Please ask for: Nicola Moore
Email: nicola.moore@arun.gov.uk
Telephone: Ext 37944
Our Ref: FP/3/22/HH
Your Ref:
Date: 20th January 2022

Application for Planning Permission for Works or Extension to a Dwelling

Development: Removal of existing conservatory and erection of single storey rear extension.
Location: 5 Cunningham Gardens Felpham PO22 7QP

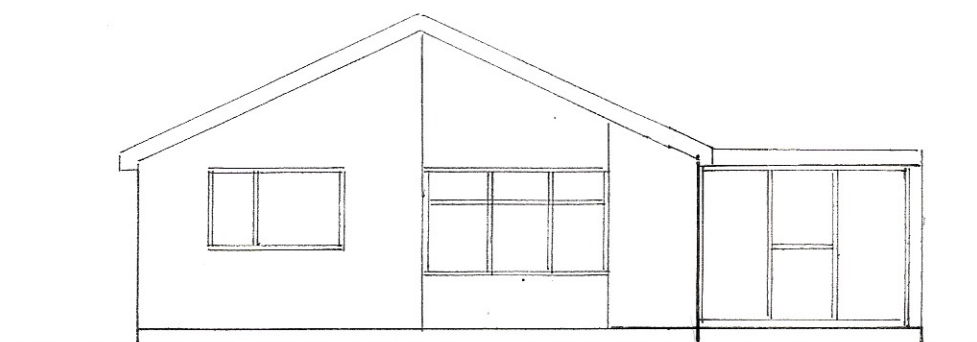
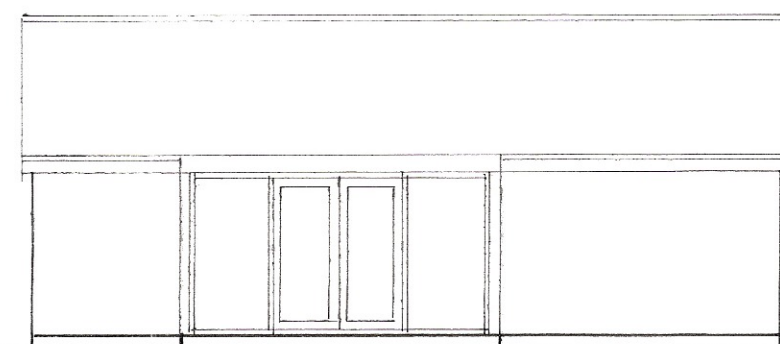
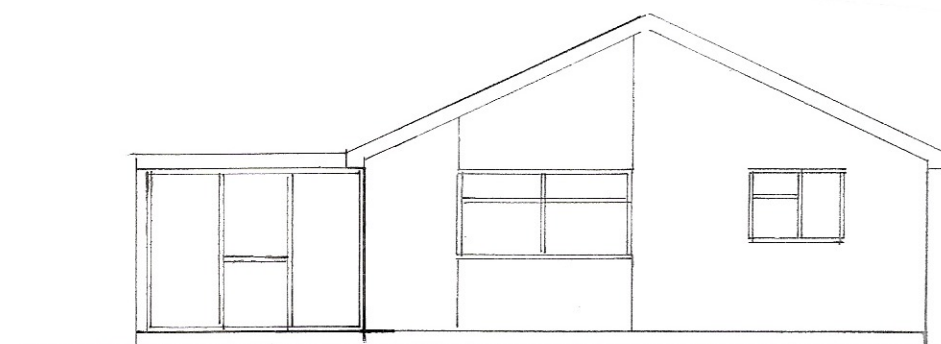
Please amend the Proposed Elevations (Sheet 2 of 3) to include the scale and re submit.
